Our Case Number: ABP-318093-23

Re: Proposed road development at The Quay, Quay Street, Suir Island and Raheen Road
The Quay, Quay Street, Suir Island and Raheen Road, Clonmel County Tipperary

**Report on Proposed footbridge at Suir Island Clonmel
(aka Suir Island Infrastructure Links project)**

Reference: HA92.318093 (Closing date for comments 18th Dec 2023 at 5.30pm)
Decision date May 2024 ABP History – Lodged 25-9-23

TIPPERARY COUNTY COUNCIL
Client
SUIR ISLAND INFRASTRUCTURE LINKS
Project
EXISTING & PROPOSED QUAY PLAN
Dwg. Title

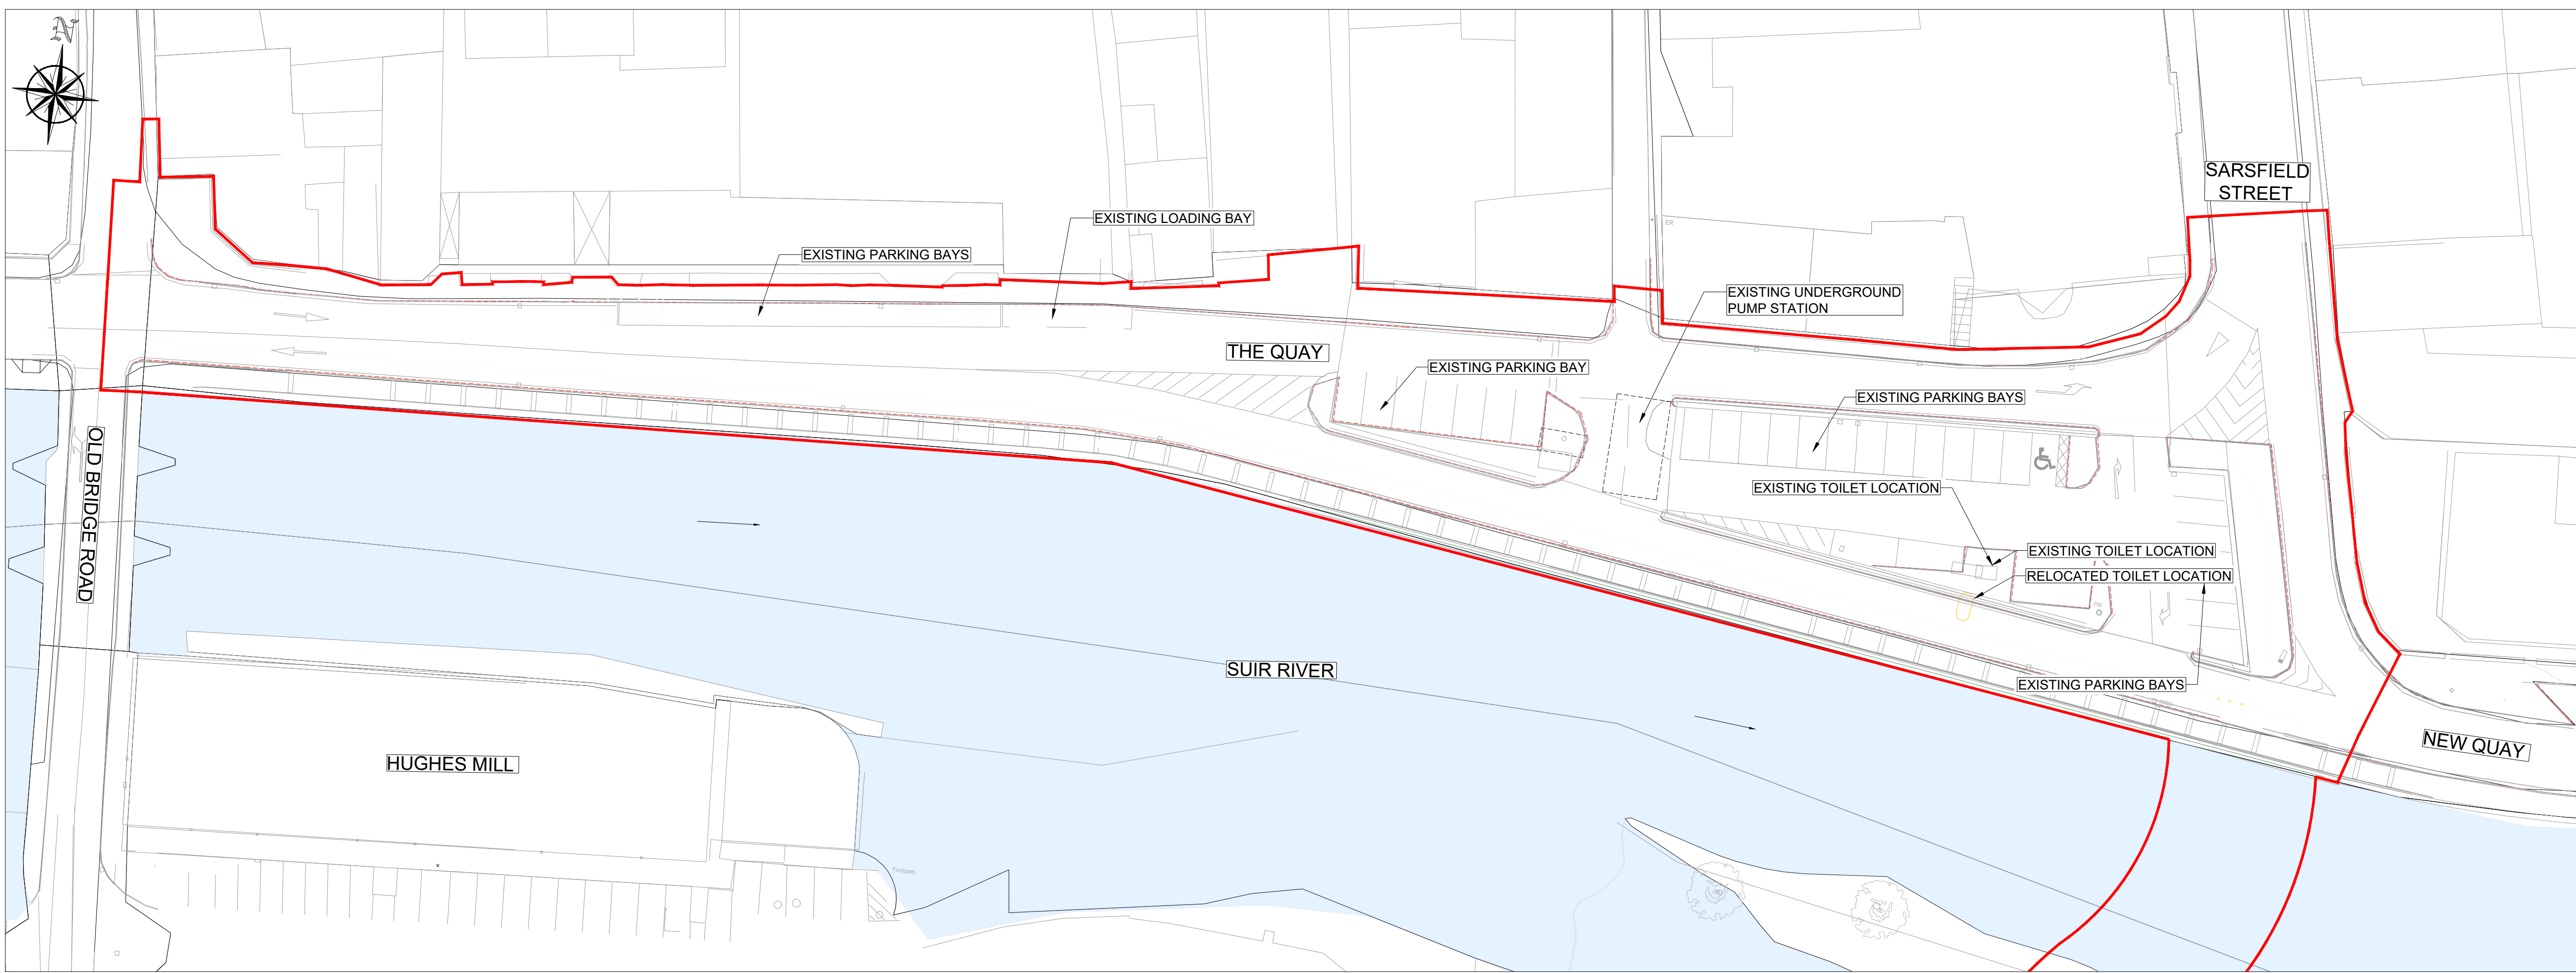
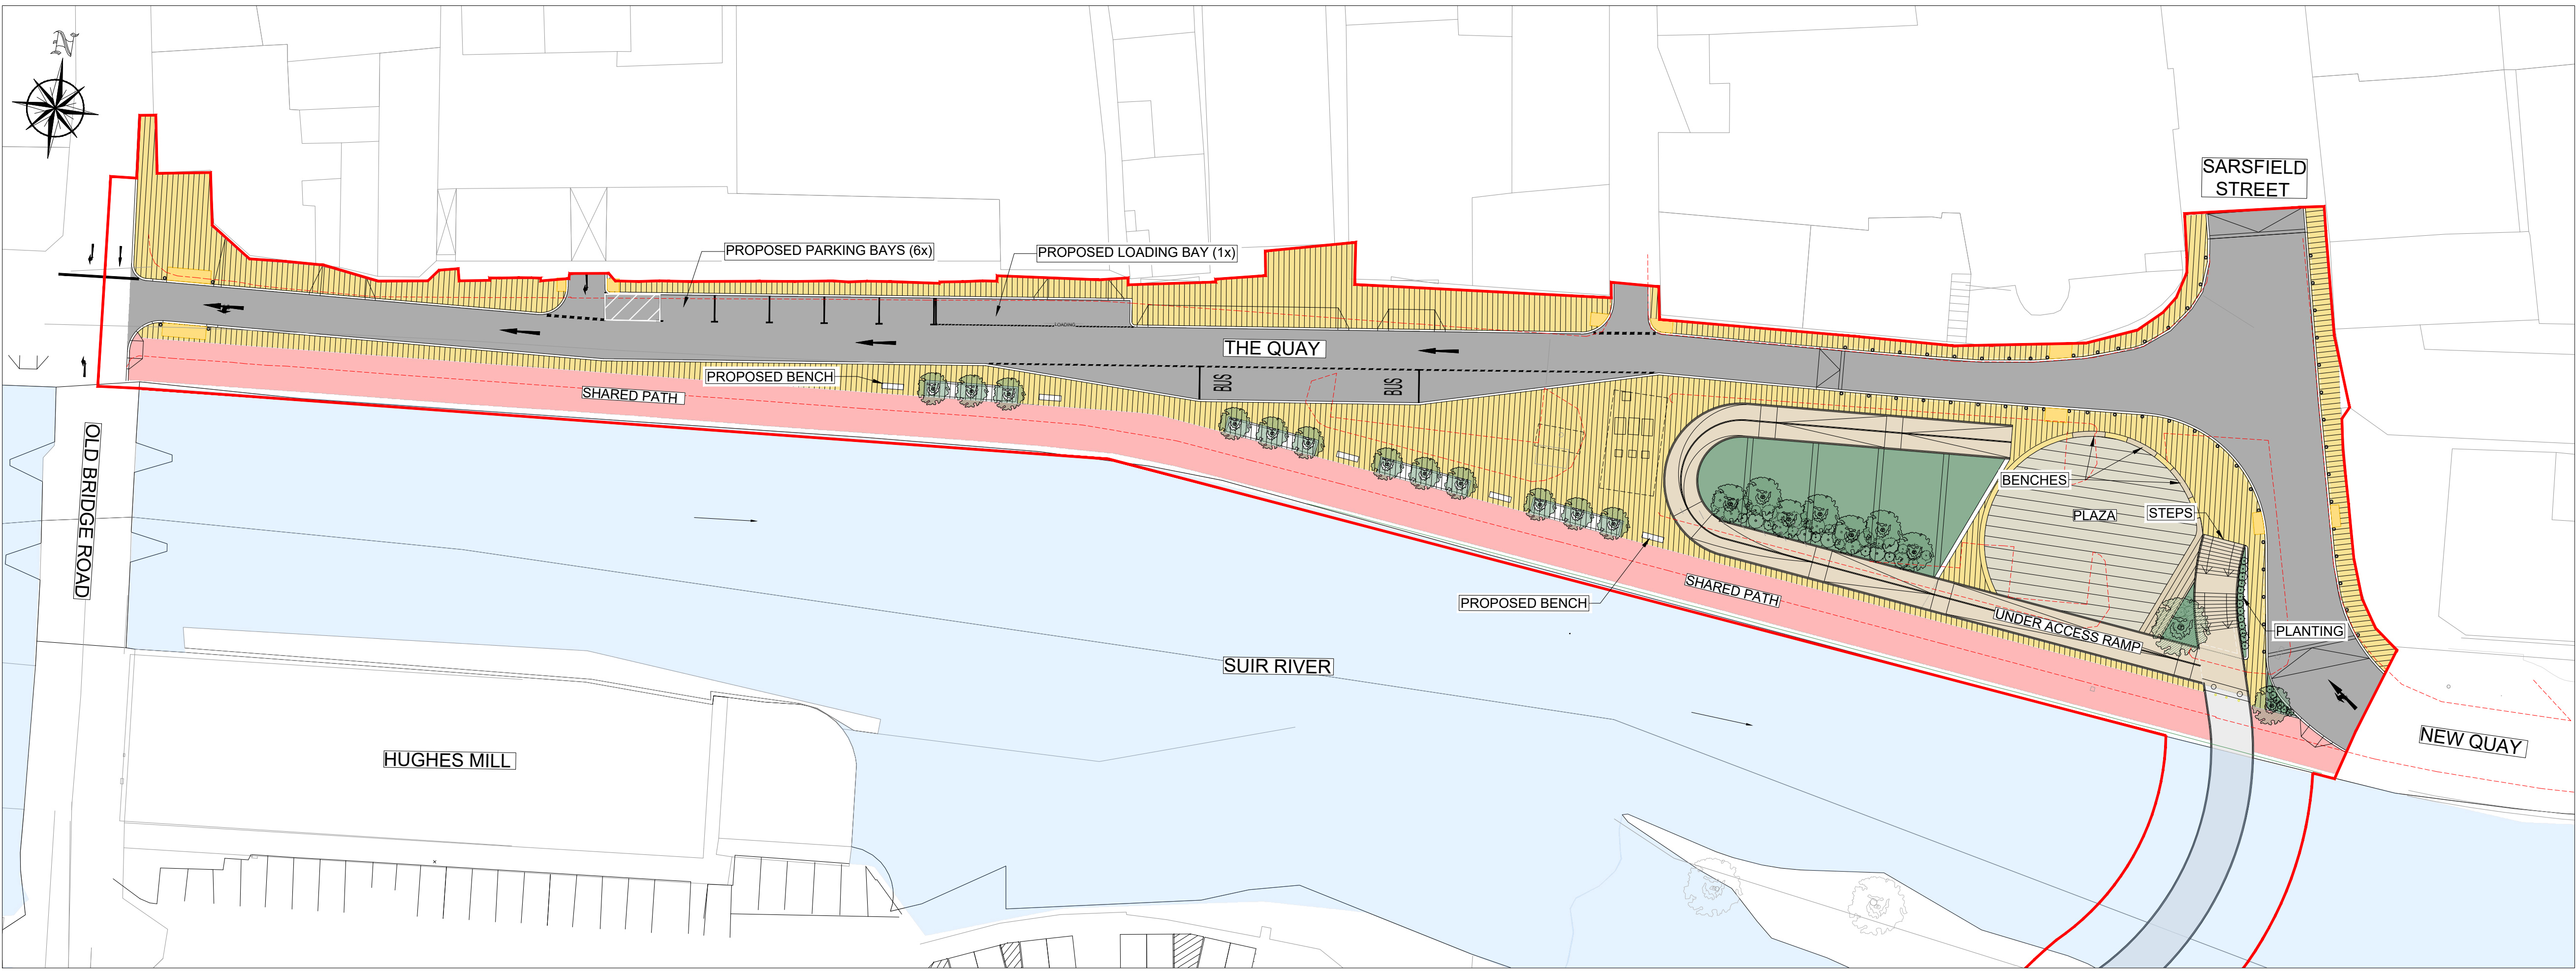
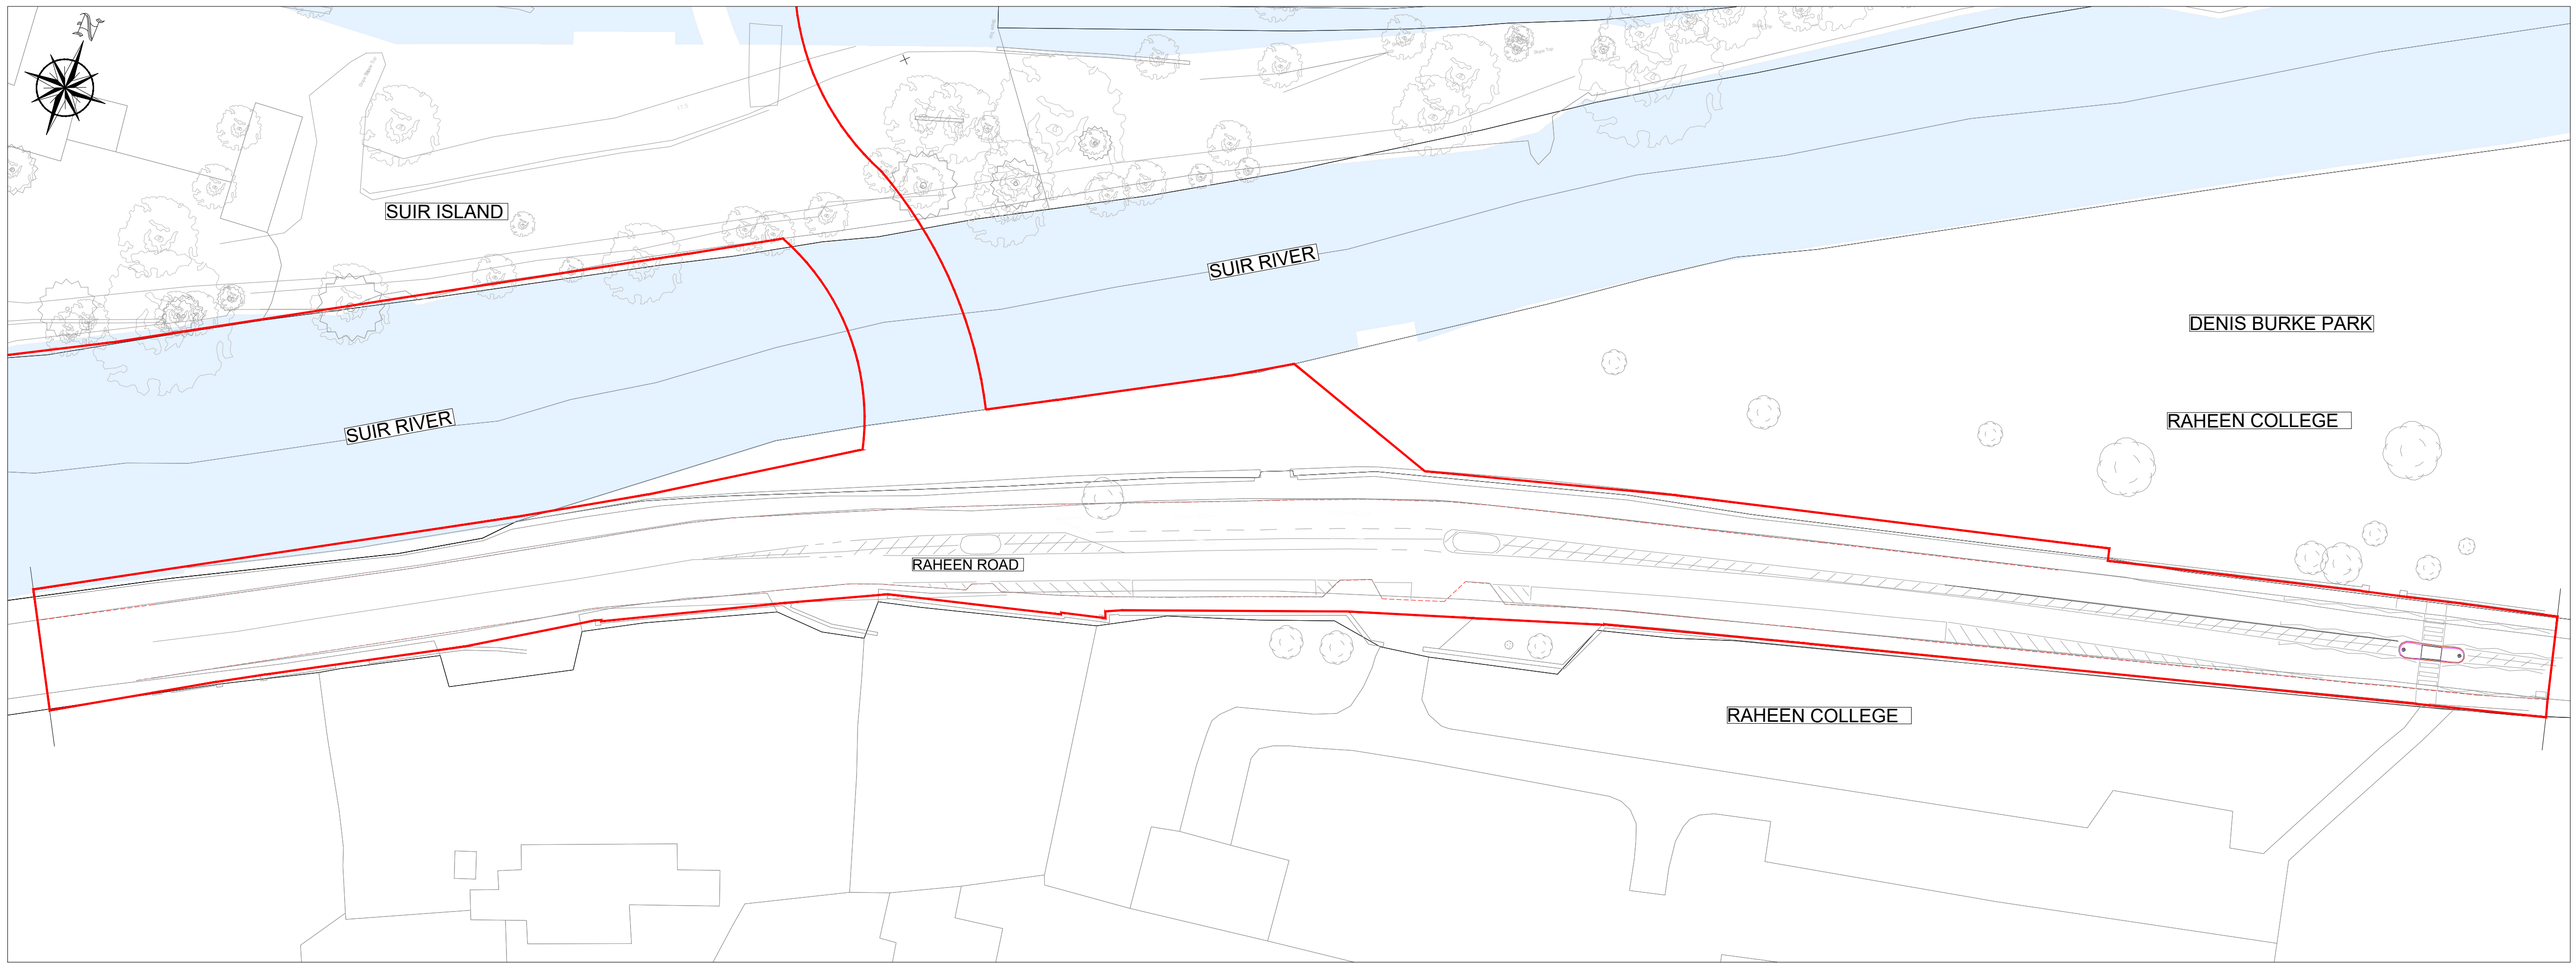
(f) The Author also considers there will be a significant Road Safety hazard for vehicles driving along the Quays as a new 90 degree bend is proposed for all traffic compared to the current layout where the majority of traffic heading westwards faces no obstruction at Sarsfield St junction. The author suggests new road safety measures (e.g. ramps, signage & road-markings) will be required on the Quays ahead of Sarsfield st to slow down traffic. This potential road safety hazard has not been assessed by the consultants in their "Optioneering" of the various proposals and is a matter of concern given the increasing volume of urban accidents (including Clonmel) where speed has been a contributory factor.

(g) The proposal to change traffic flows on the quays from two-way to one-way will have a major effect on local residents and businesses in Clonmel Town Centre (to be discussed in detail hereunder). The Author has 23 years of local Traffic engineering knowledge compared to the external traffic consultant who has apparently only 3 years experience along with the local knowledge of staff currently working for Clonmel Borough District who don't appear to have given sufficient time to adjudicate fully on the Consultants final proposals. This conclusion is based on date of the ABP decision to seek an EIAR dated 18 Sept 2023

(h) The proposal to remove 34 valuable car-parking spaces in this “side street area” off the Primary Retail Area has been poorly evaluated in the Author’s opinion with lack of adequate surveying of traffic and parking in the submitted Traffic Impact Assessment. Clonmel is one of the largest inland towns in Ireland and has a very busy town centre area by day which depends solely on surface car-parking both on-street and off-street. During the “Celtic Tiger” boom years of 2000 -2009, the Author is aware that the Borough Council sought to have a multi-store car-park (MSCP) with ground-floor retail units constructed at the existing Mary St surface car-park. Despite tax-breaks available, these efforts to set up a Design-Build-Operate-Finance (DBOF) project failed to materialise for various reasons including trying to maintain access to some 40 “rights of way” off the car-park. Prospective car park operators also considered that an MSCP at this location would not be viable & they sought assurances on an increased level of on-street enforcement and clamping which the Council could not deliver in the political climate at that time. Subsequently extra surface car-parking was constructed at Suir Island - prior to 2008 most of Suir Island was a derelict site (Old Creamery) partly owned the Local Authority and subsequently enlarged following some land acquisition. It should also be noted that Suir Island car-park has approx 26 “private spaces” including 7 “reserved” spaces at Hughes Mill apartments/former retail units. These “private spaces” are not referred to in the Consultants proposals and they limit the full capacity of the site. A recent on-site count of the available “Public pay & display spaces”(following camper van changes last year) indicates 214 spaces including 10 disabled and 4 EV charging spaces. This is 50 less than the EIAR stated figure of approx 264 spaces which appears to include the fenced-off private spaces at the Apartment building and spaces now dedicated for camper vans etc.
